CITY OF ALBUQUERQUE

September 29, 2016

Re: Project Name
5502 4th St NW
60-Day Temporary Certificate of Occupancy- Transportation Development
Architect's Stamp dated 09-29-16 (F14D013)
Certification dated 09-24-16

DD FRESH BREW / BR FLAVORS 1.0 COMBO DESIGN GUIDELINES
SCHEMATIC SITE PLANS AND TRAFFIC CIRCULATION LAYOUT
PC NUMBER

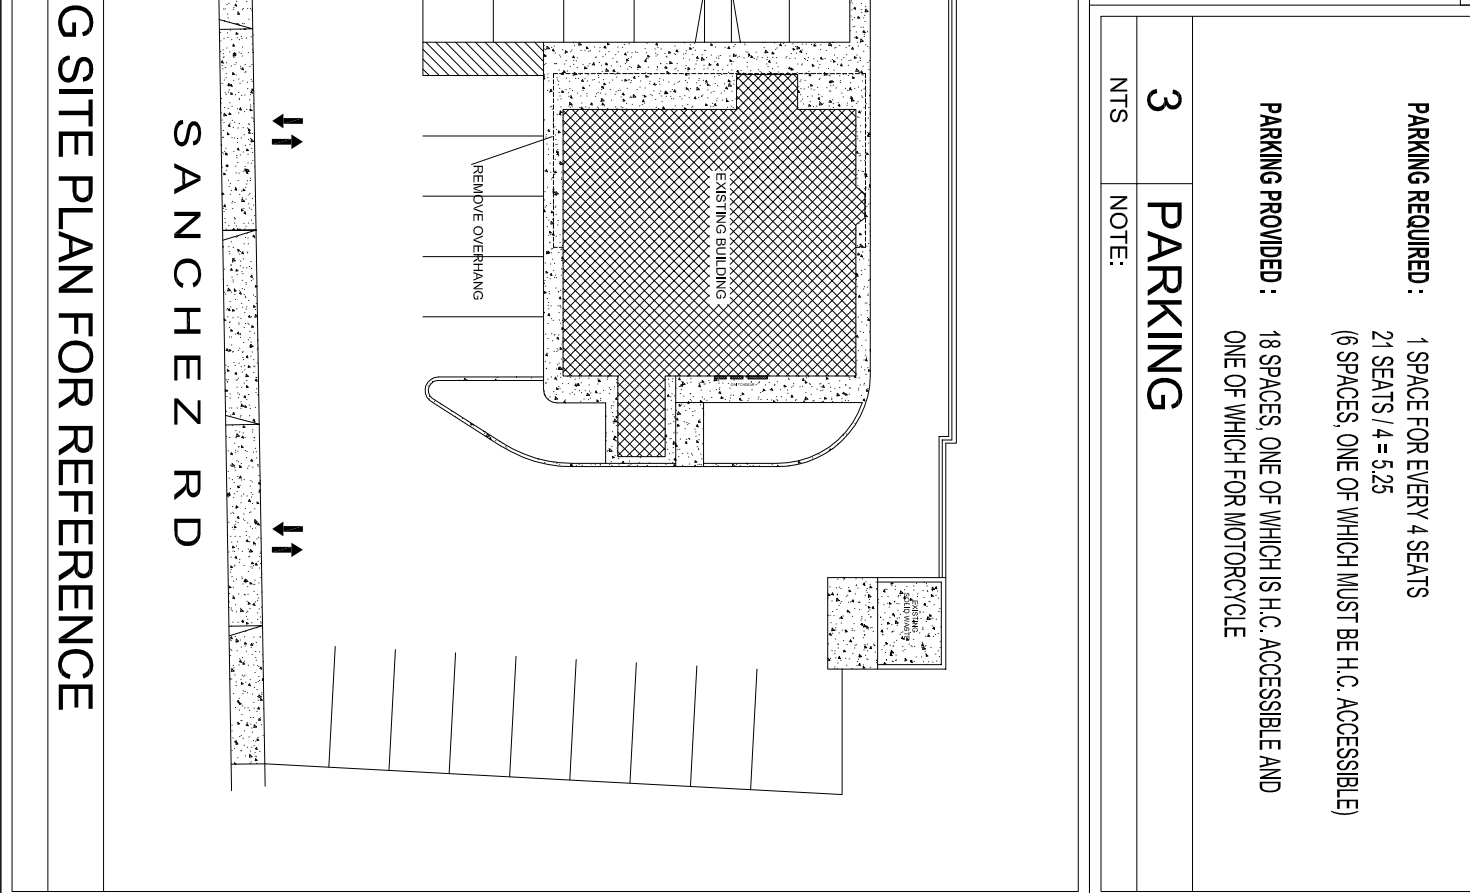
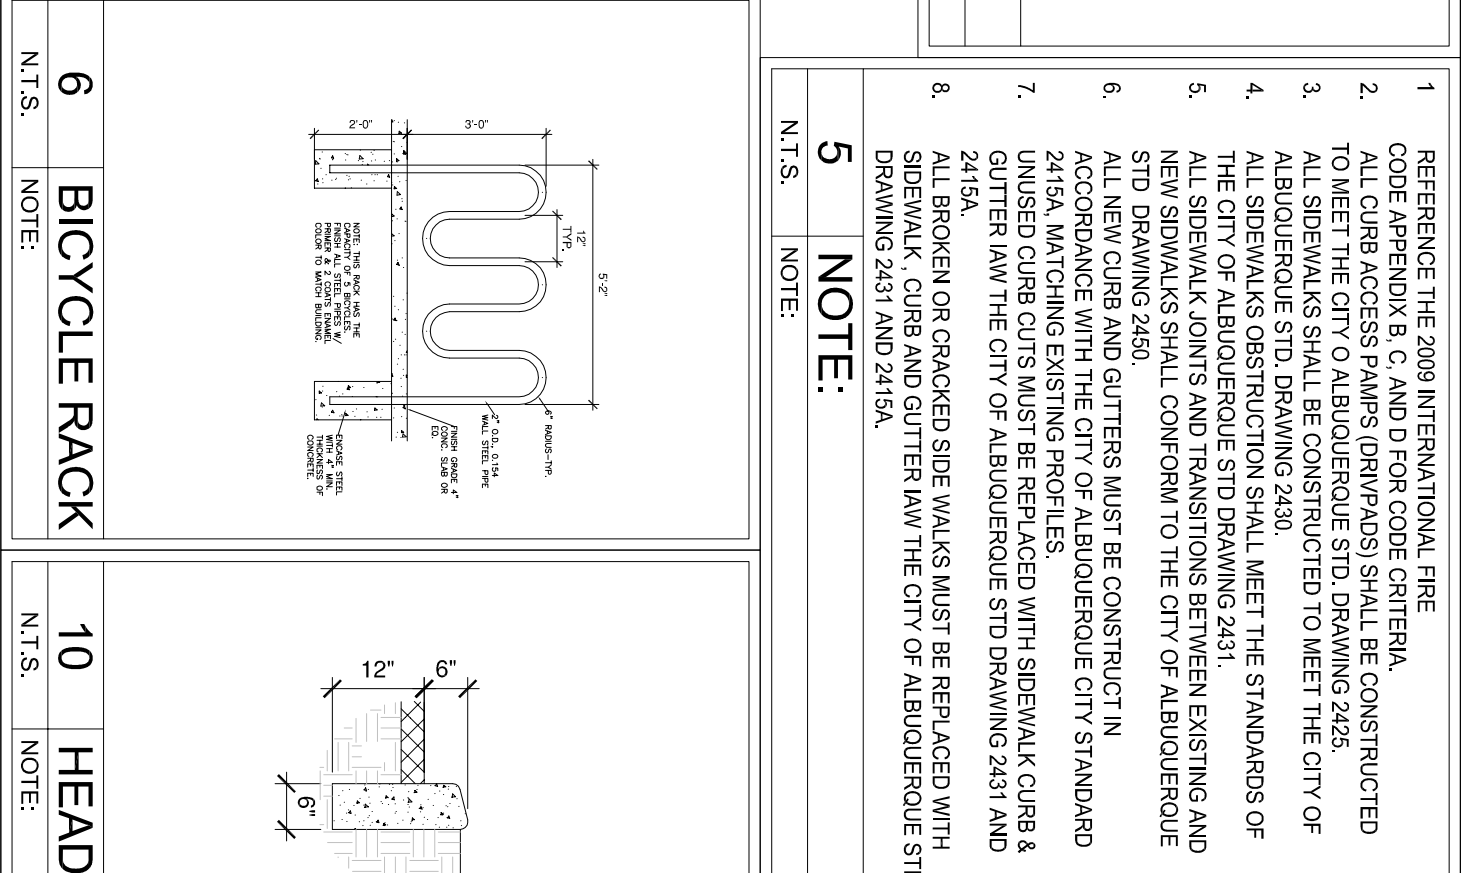
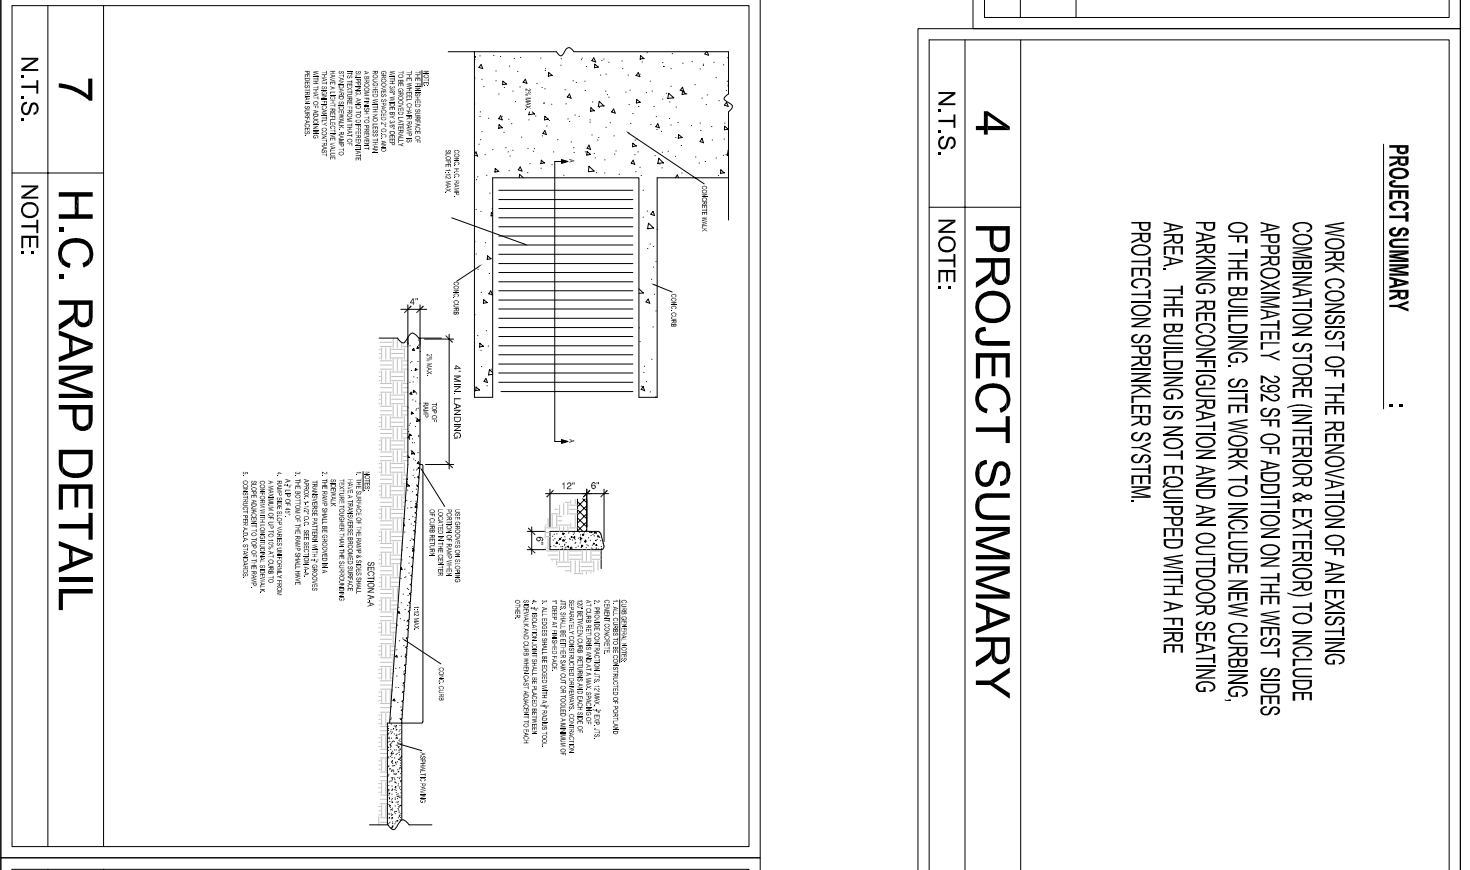
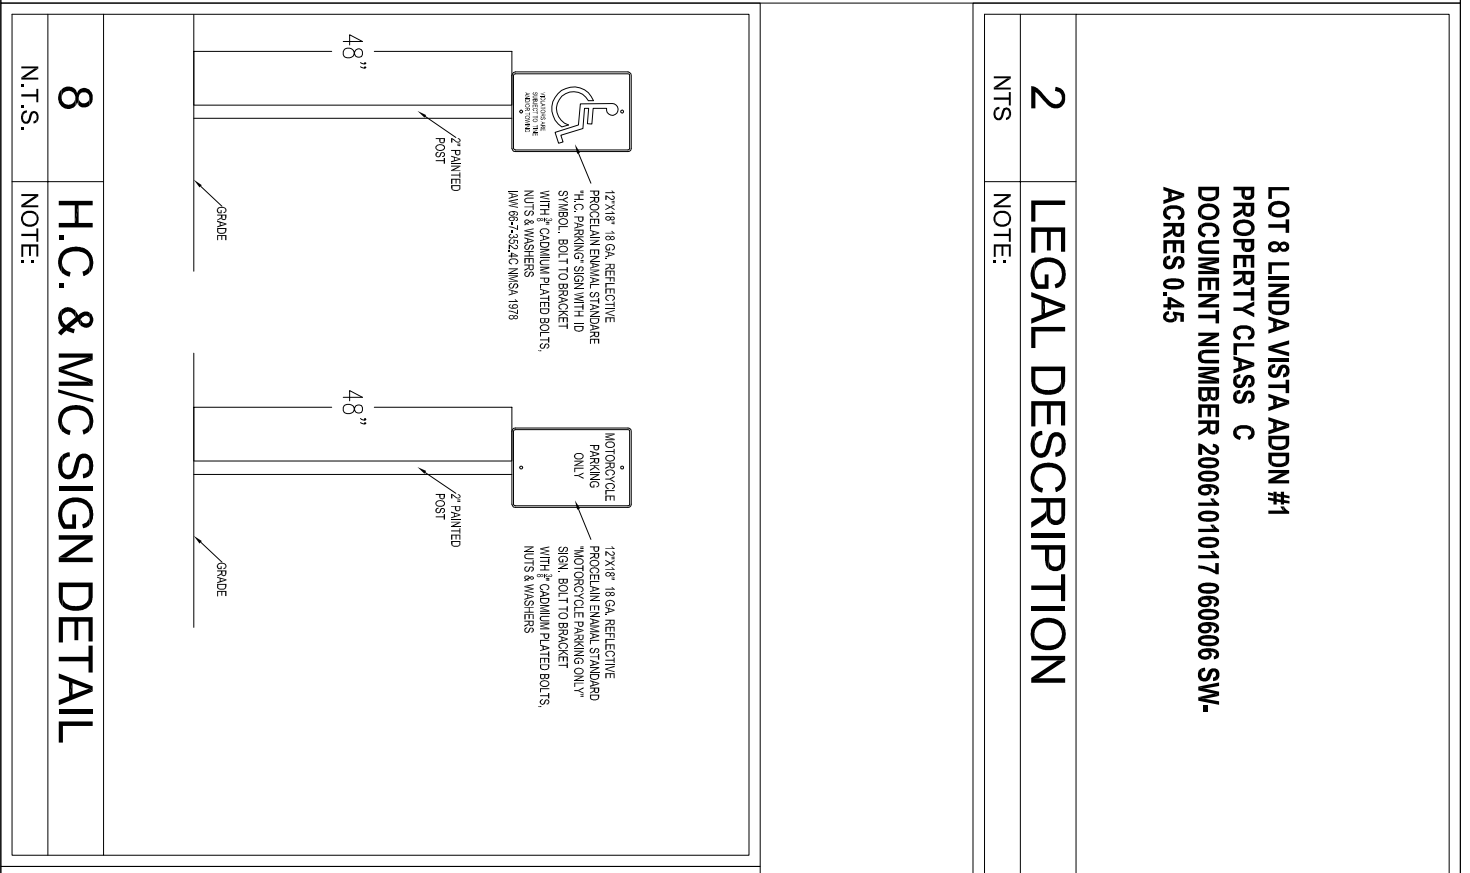
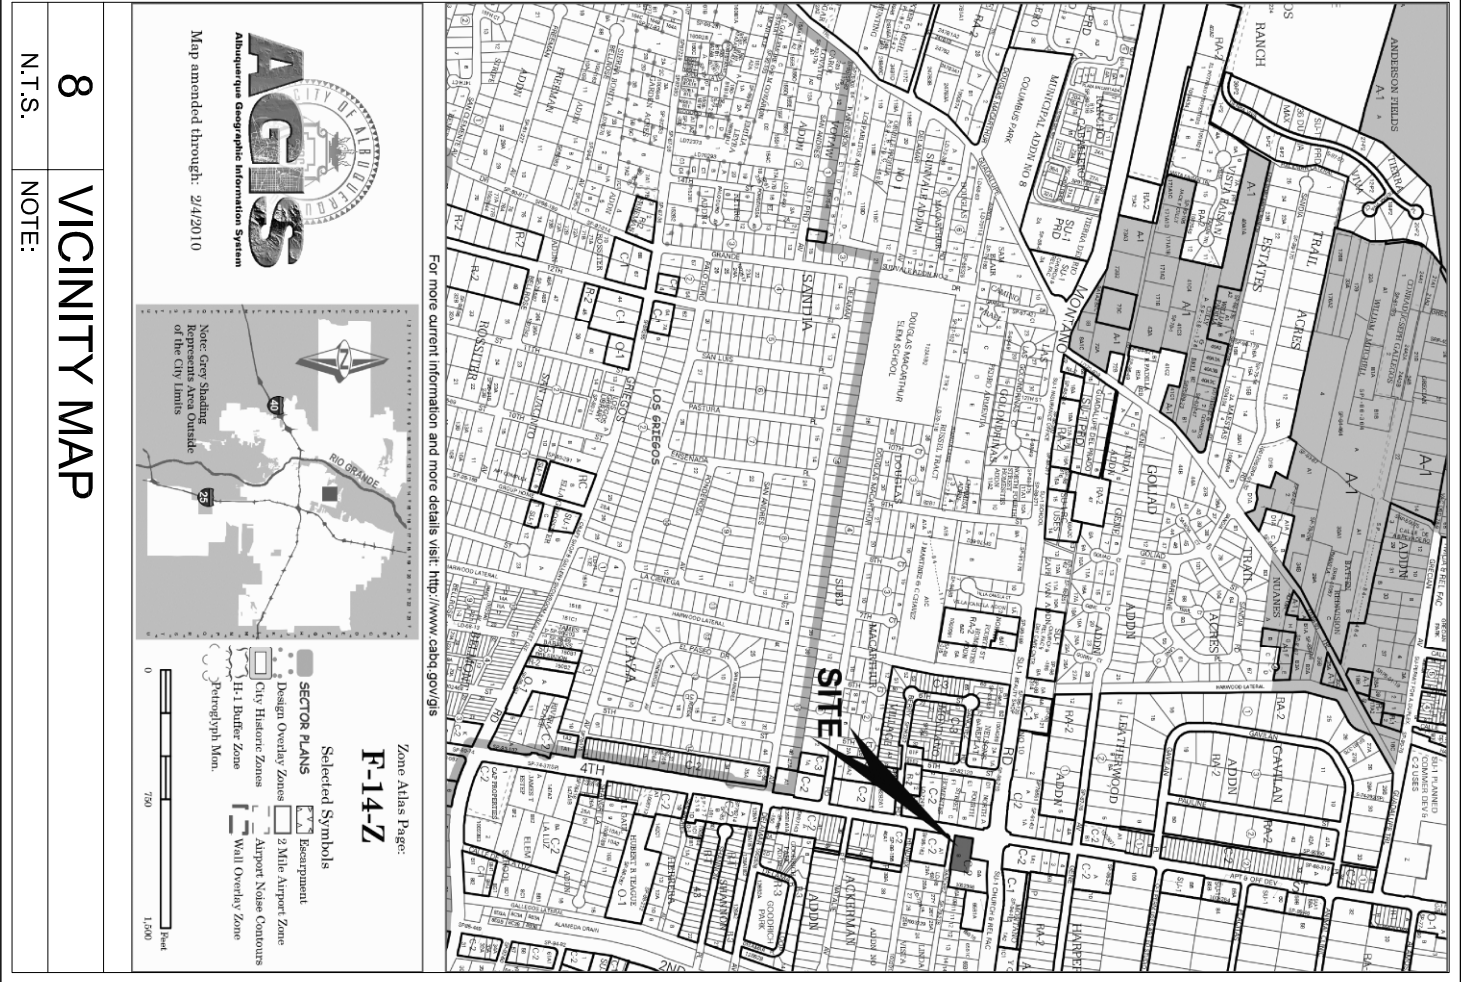
1. The two curb cuts located along 4th St NW will need to be closed due to safety concerns prior to issuance of final Certificate of Occupancy.
2. The stamped approved TCL dated 07-01-2016 will need to be redlined and submitted for Final Certificate of Occupancy inspection.

- "START" stencil has been eliminated near the drive thru menu board.
- Bollard at menu board has been eliminated
- Bike rack has been relocated
- Shifted the Drive Thru arrow to the west as shown on new plan
